From: Trevor Dixon
Sent: 16 June 2022 14:37
To: Andrew Lewis
Cc: DC Support
Subject: 22/00747/OUT - Land At Bicester Road, Kidlington

Based on the information submitted with the application my comments are as follows:

Figure 6-2: Future noise contours with development and noise screening

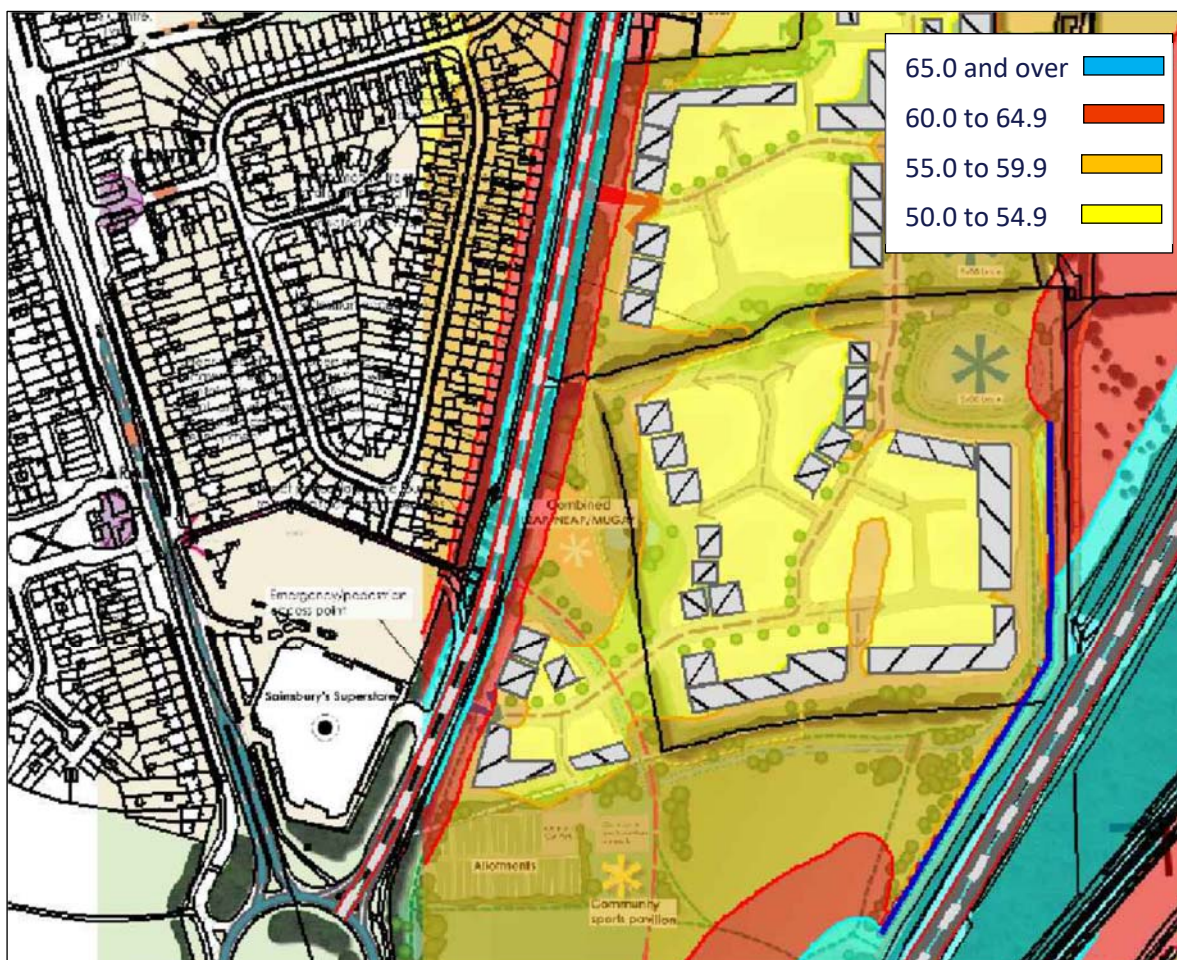
With a 6m barrier external levels in some areas will exceed 55dB(A). The assessment should include modelling and noise contours with higher barriers in place to demonstrate if a level of 55dB(A) or lower can be achieved in all areas. The assessment should also consider external amenity areas in the Southern area of the site.
